From: Laura Gibbons <Laura.Gibbons@arun.gov.uk>
Sent: 19 April 2022 14:25
To: Planning.Responses <Planning.Responses@arun.gov.uk>
Cc: Simon Davis <Simon.Davis@arun.gov.uk>
Subject: RE: Planning Re-Consultation on: AL/28/22/DOC

Engineers Comments Regarding Condition 10

Application No: AL/28/22/DOC

Description of Works: Approval of details reserved by condition imposed under AL/20/21/PL relating to condition 10-surface water drainage. Decision due 28.04.22

AQUACELL SURFACE WATER STORAGE TANK
(Scale 1:20)

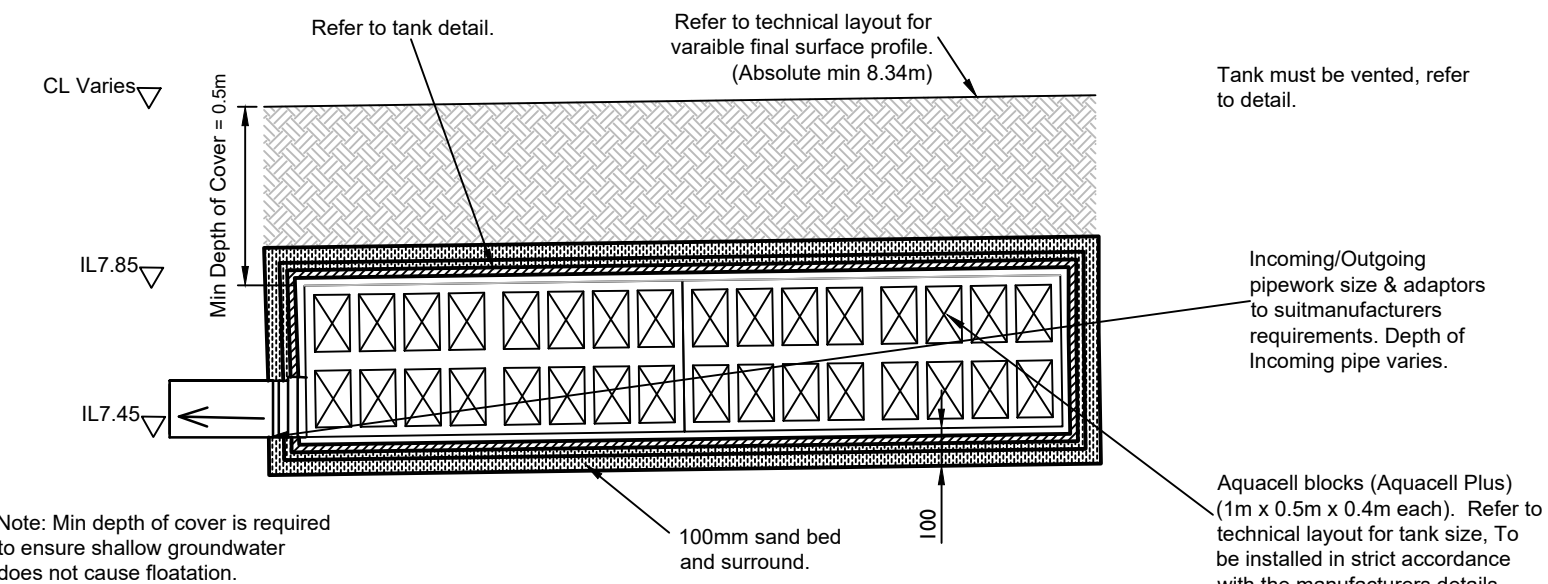
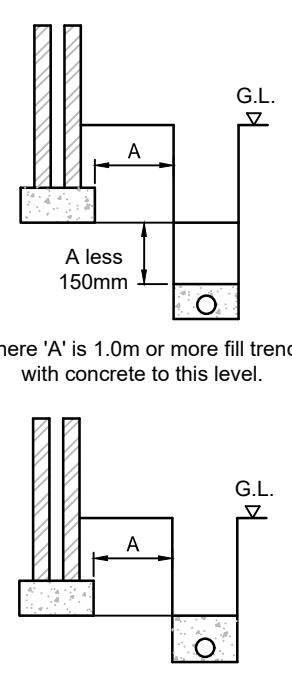
14. Please detail overflow level on S23 construction detail drawing. *Level of overflow is still not detailed.*
15. Please detail membrane around attenuation tank on construction detail drawing. Please make detail site specific. *Okay.*

PLAN
FLOW CONTROL CHAMBER S102
(Scale 1:20)

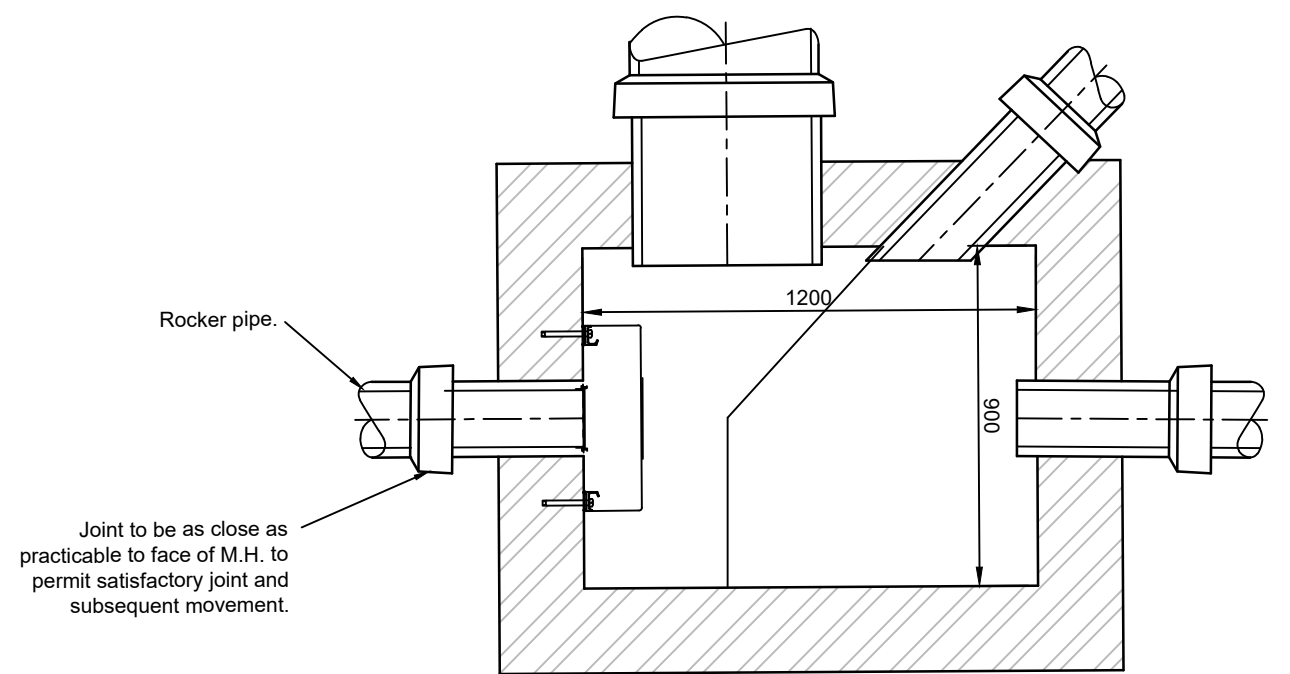
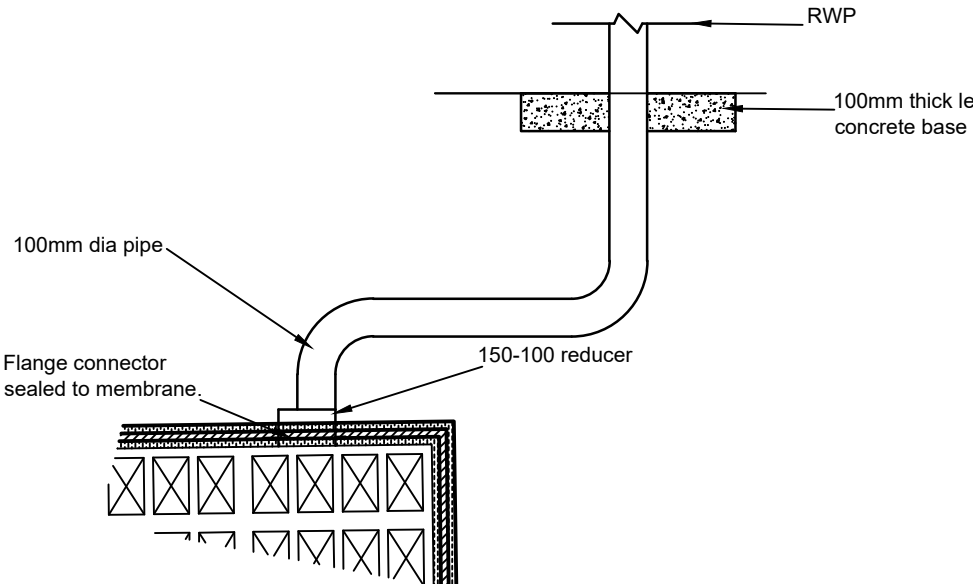
5. Please provide exceedance flow drawings. *Please detail how water will drain from the low points in the open space area.*
6. Please detail hydrobrake unit references on layout and details. *Provided, but will be impacted by comments 2 and 3 above.*

13. Please provide data sheets to evidence flow control devices for S102 and S23 will achieve the criteria within the flow model. *Provided, however please see points 2 and 3 which will alter this.*

BAGWORK HEADWALL

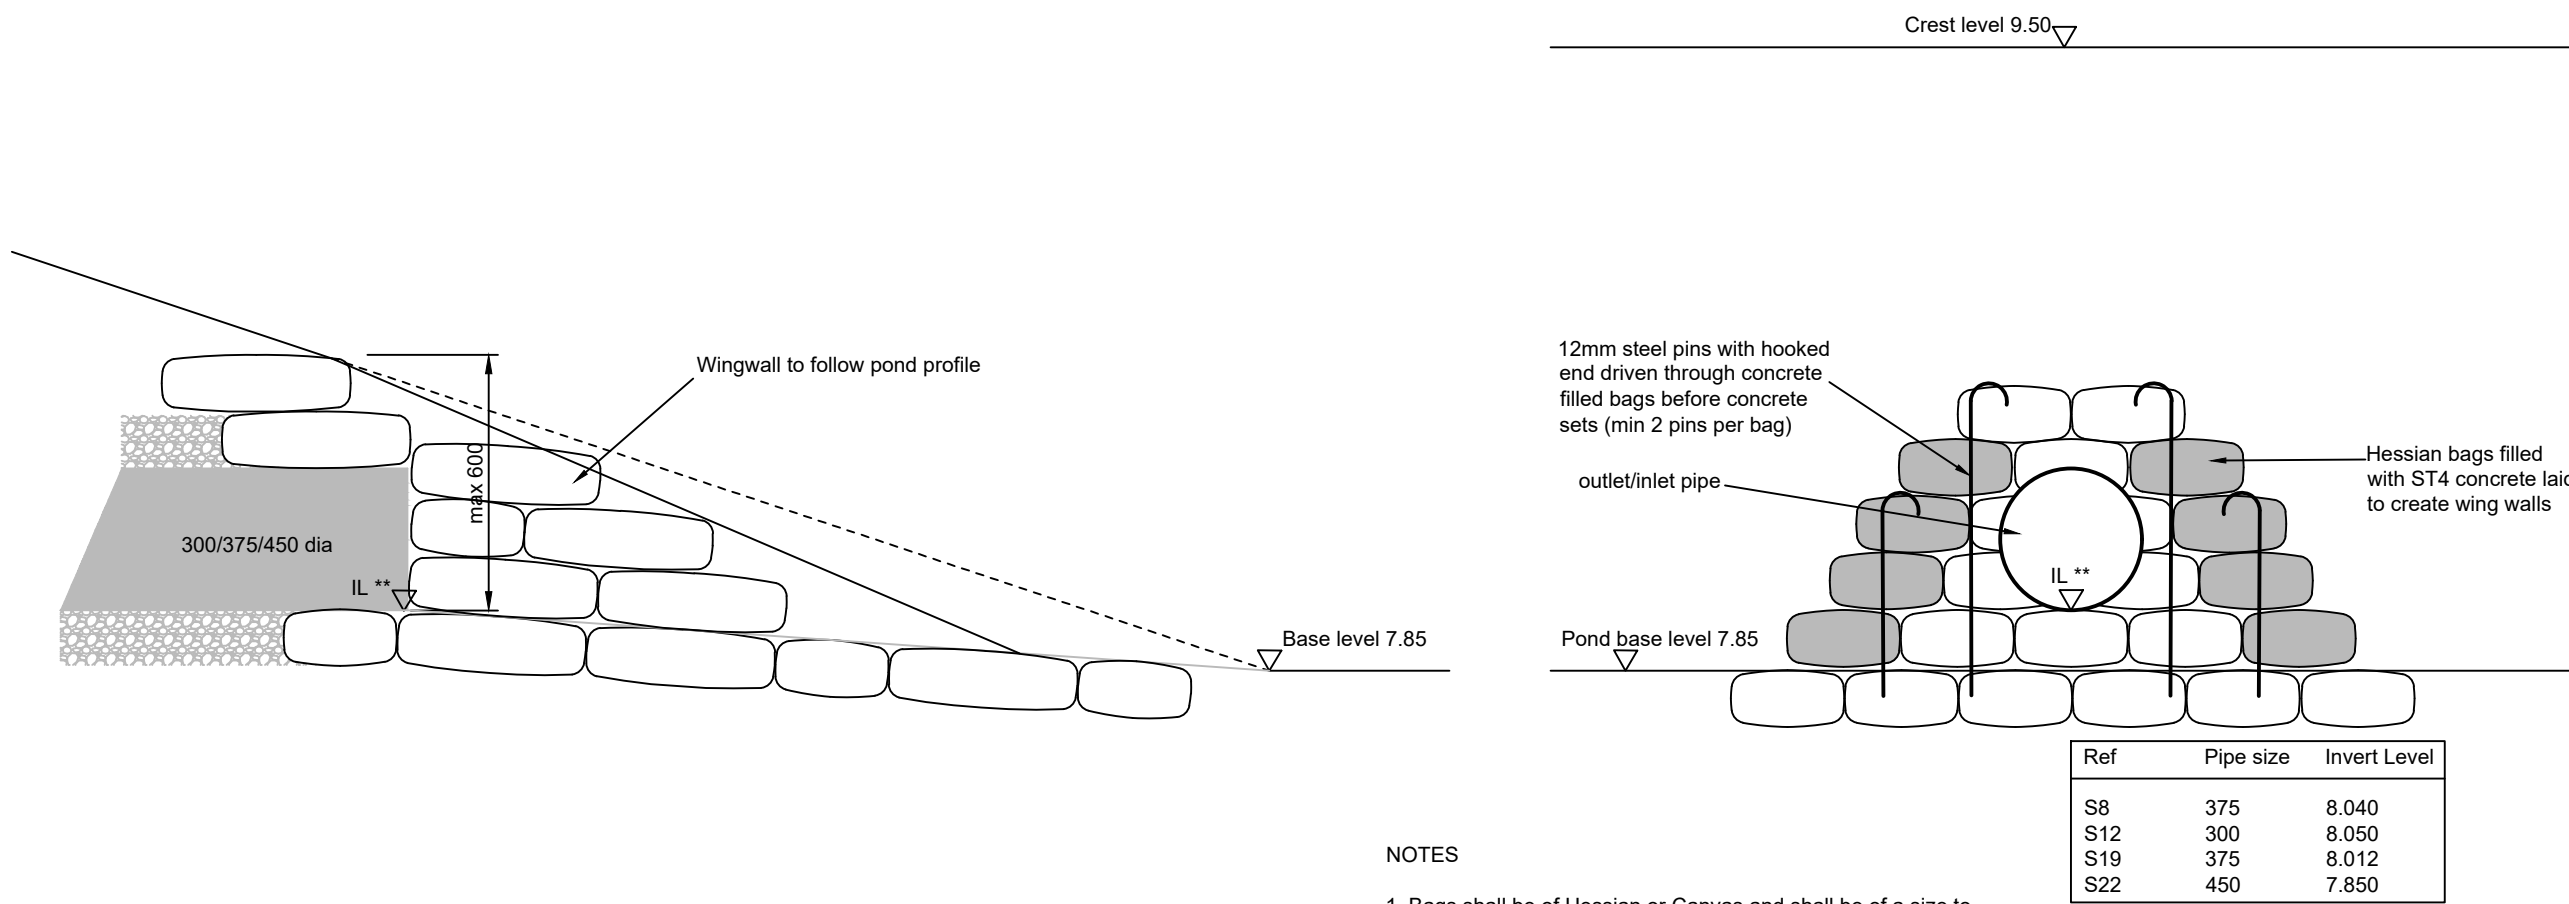
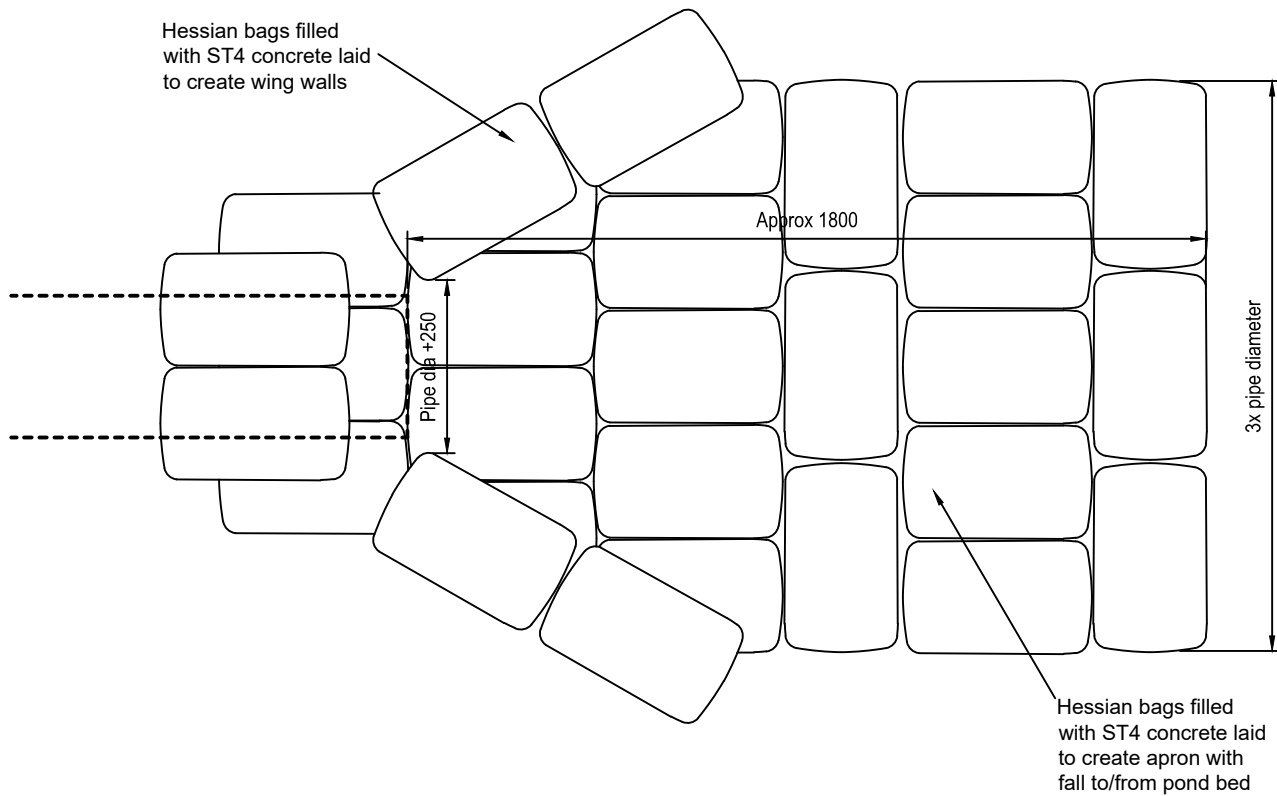
18. For the bagwork headwalls to the basin- please detail bag size, how full bags are to be with ST4 concrete, how bags are to be compacted, what bond pattern is to be followed, spacing of pins, minimum width of headwalls, etc. *Okay.*
